Address: Talisker, 8 Highcroft Holmfirth HD9 3HE

Application number: 2022/92799	
What is the application for?:	Erection of extensions, conversion of existing attached barn to living accommoda
Address of the site or building:	17, Town Gate, Upperthong, Holmfirth, HD9 3UX
Postcode:	HD9 3UX

Type of comment: An objection	
Do you wish your comments to be published on the website anonymously?	No

Drawing
 Existing Site Plan with swept path

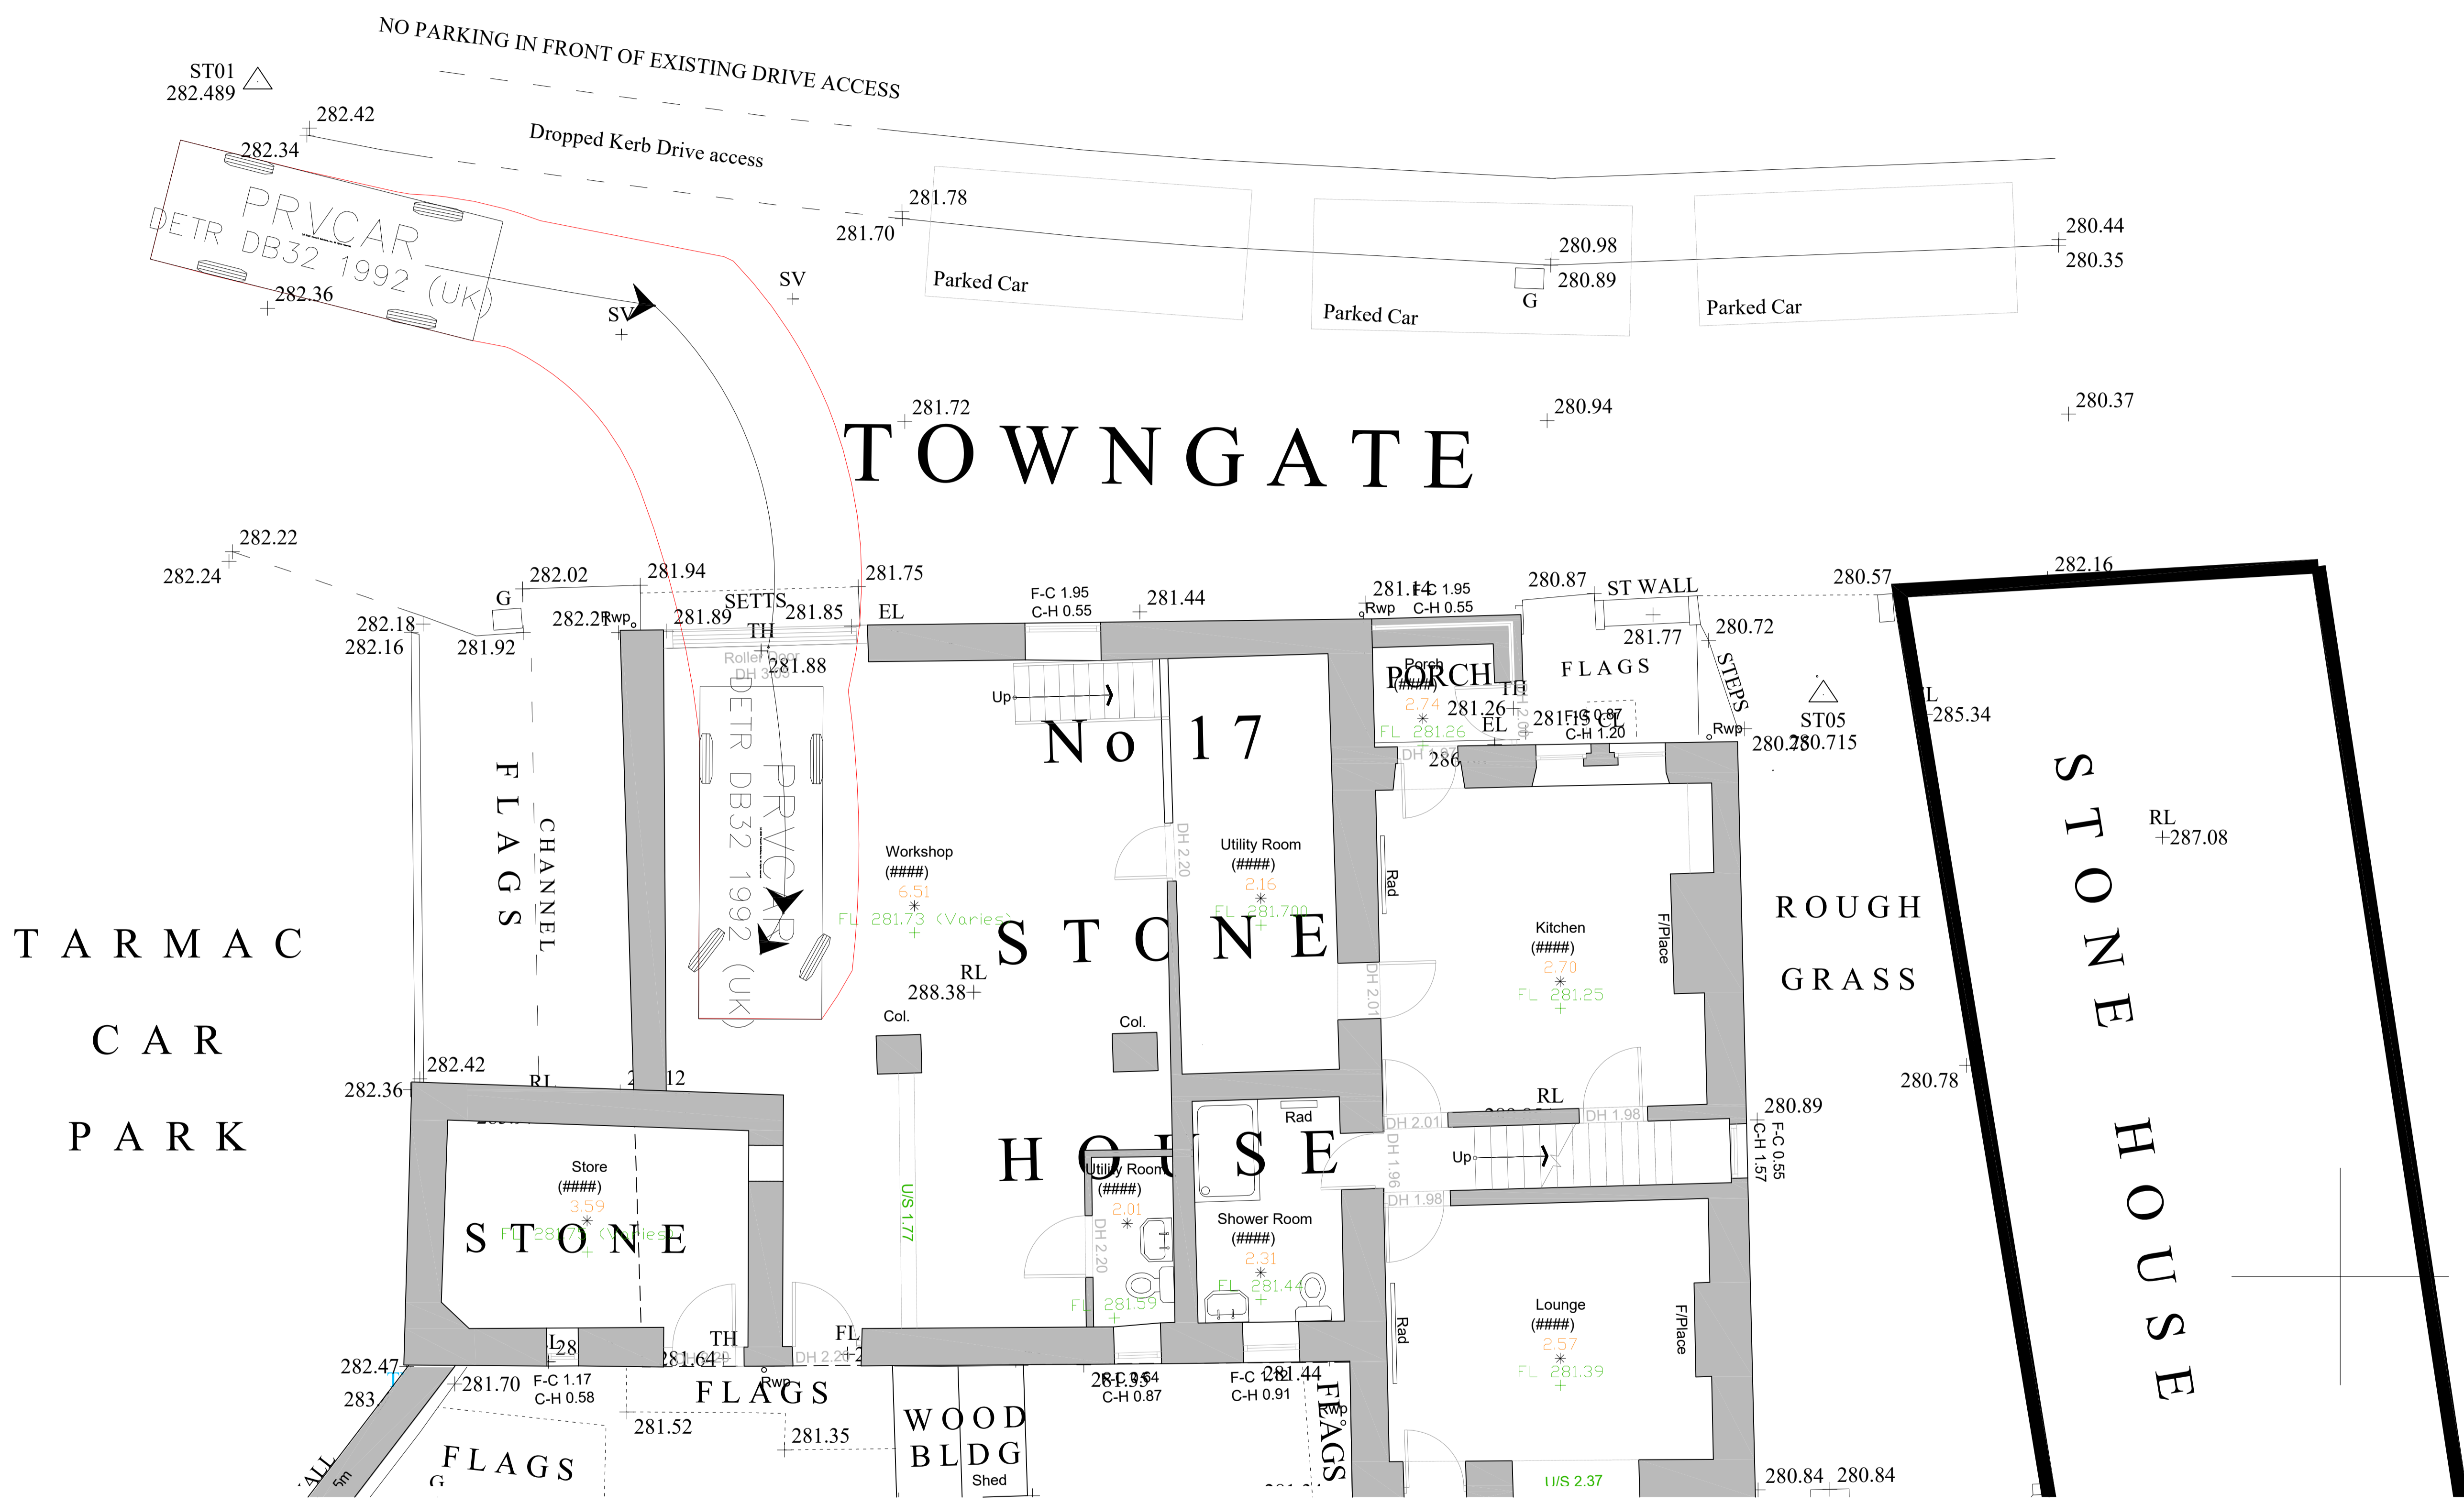
I believe that tracking should be provided to show how the applicant would enter and exit the site given the nature of the new driveway. There are no visual sight lines available to the east when exiting the property.

REV	DATE	DESCRIPTION
PROJECT		
17 TOWNGATE, UPPERTHONG		
TITLE		
VEHICLE TRACKING - CAR		
SCALE		
1:200 @ A3		
DRAWING		
2063-101		
DATE		
07.07.2022

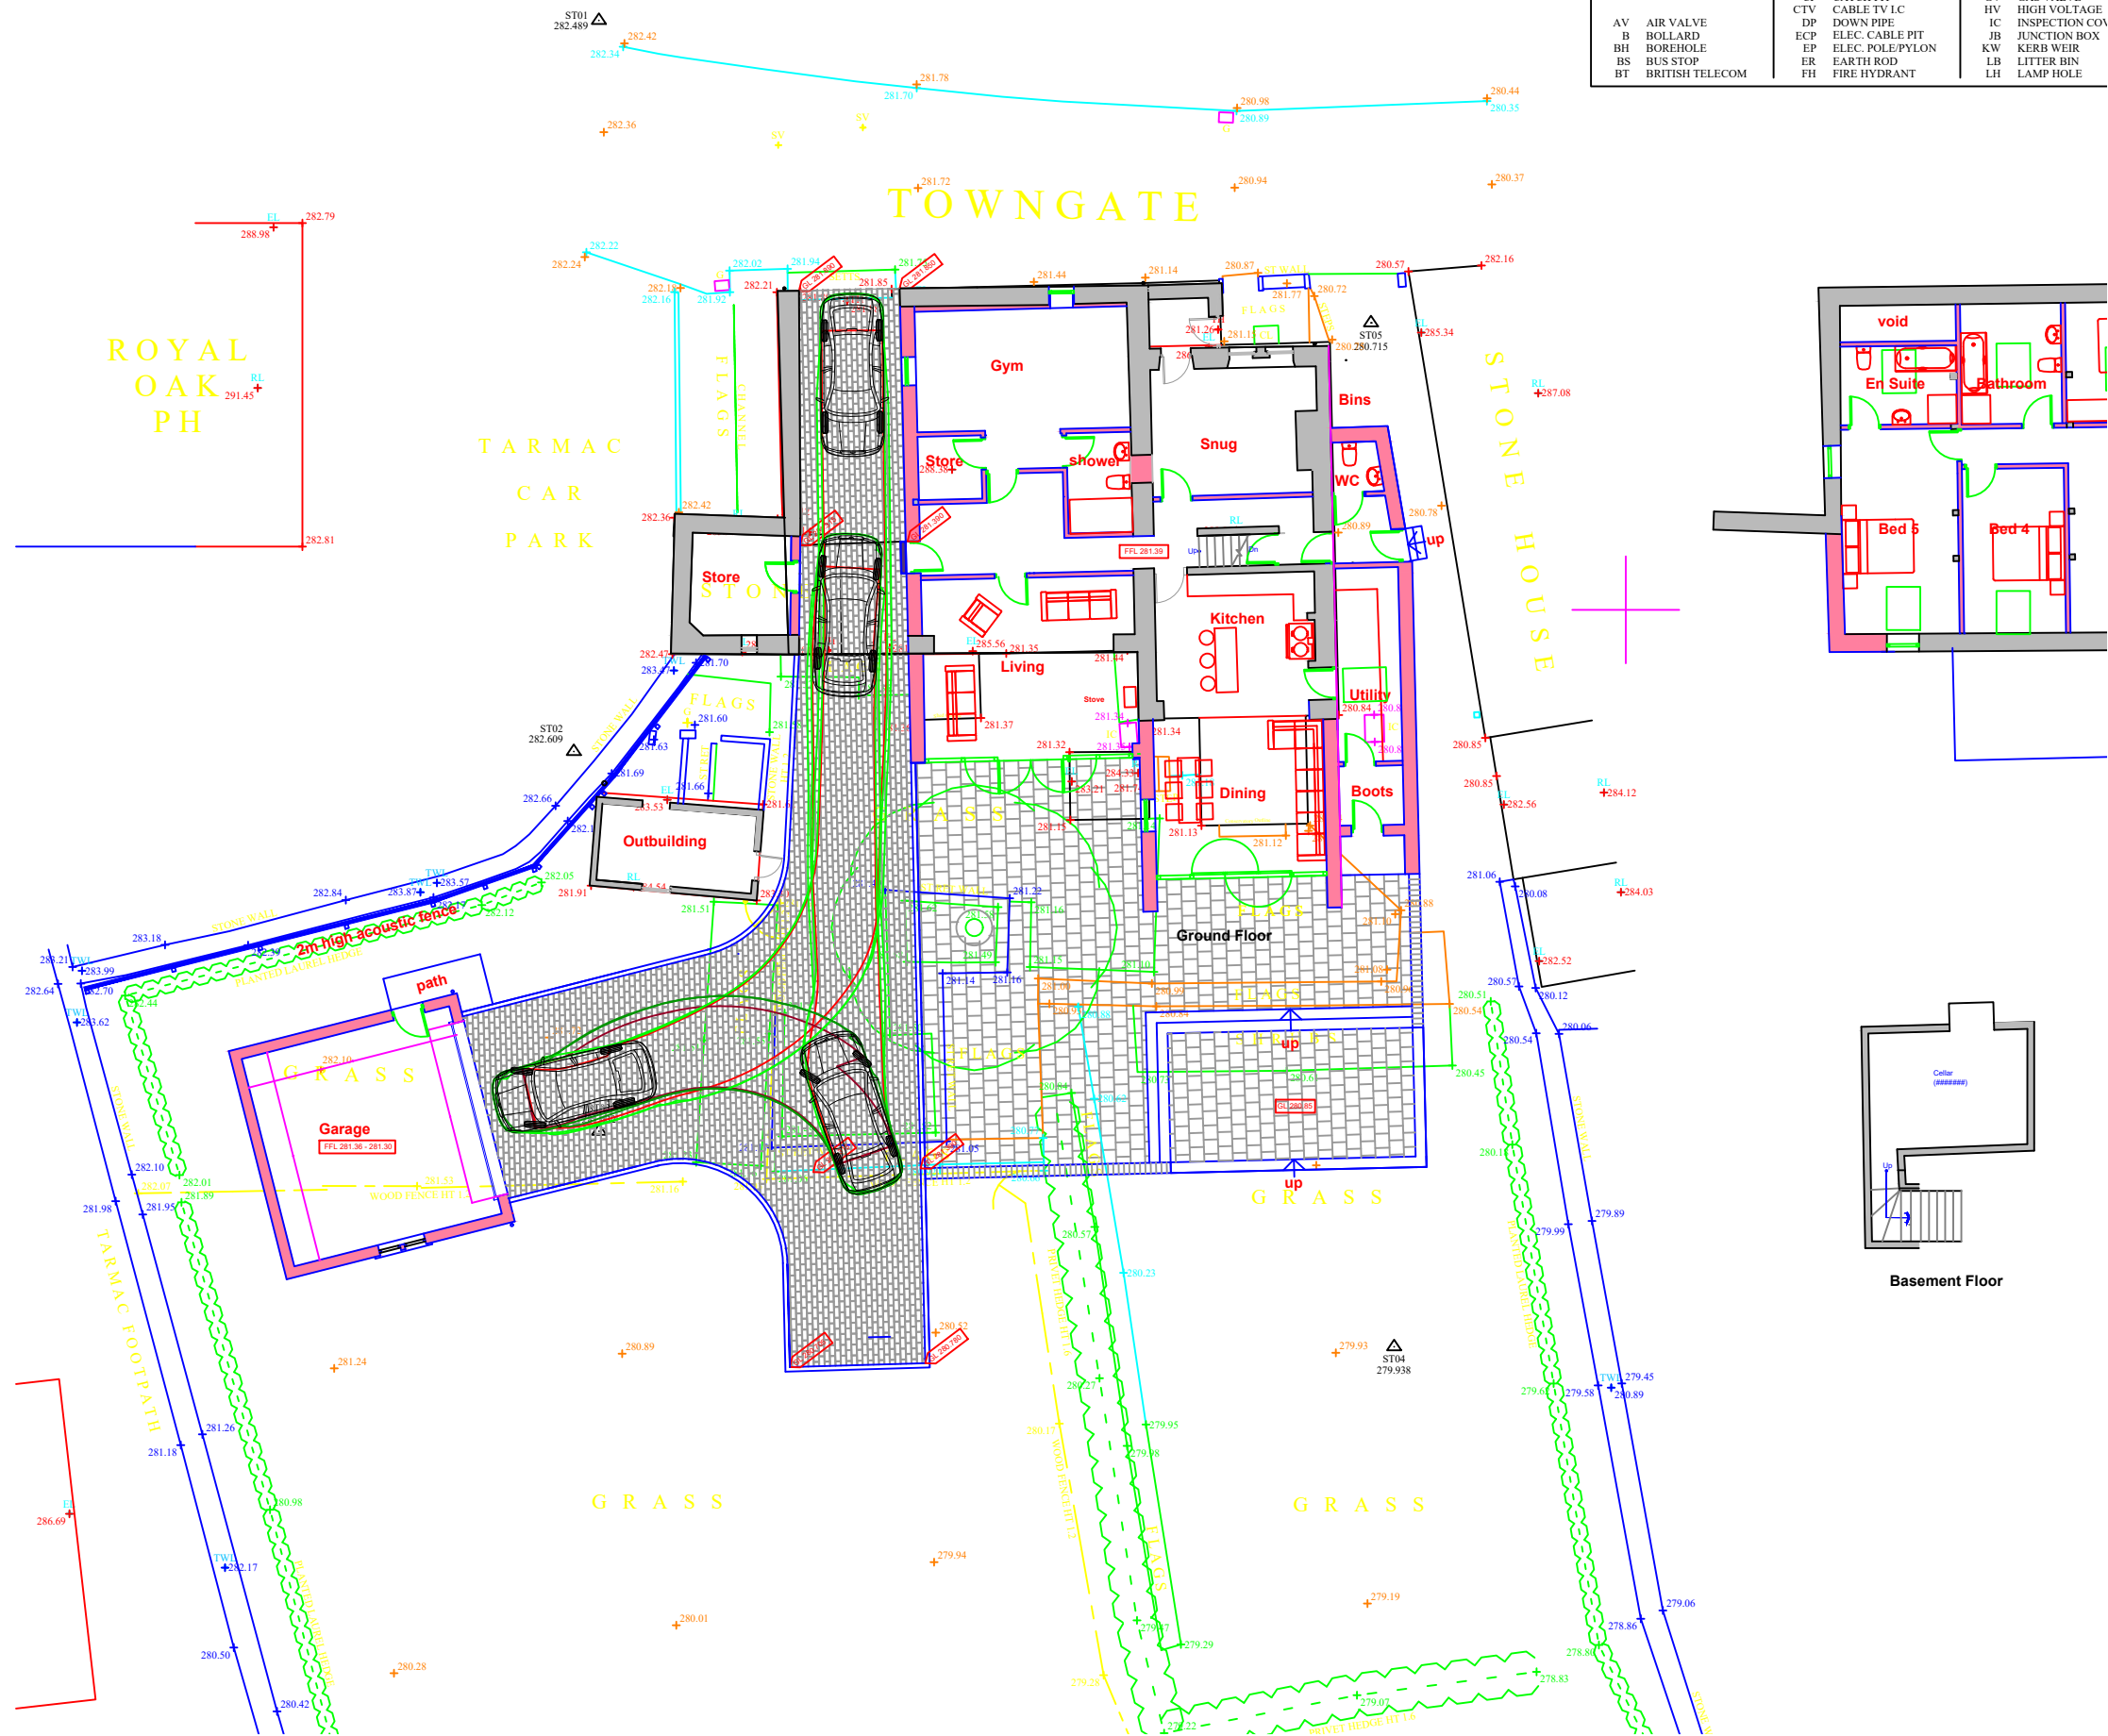
The new proposed access would create a new point of entry/exit (albeit seemingly narrow for modern vehicles) onto what is an already busy and at times congested part of the Town Gate. There are often cars parked opposite the proposed new access point.

The proposed access point is adjacent to the existing Royal Oak pub car park, which again would raise safety concerns.

The existing access at the east of the property appears to be wider than the proposed barn access, and, although still not ideal, has better visibility of the highway.
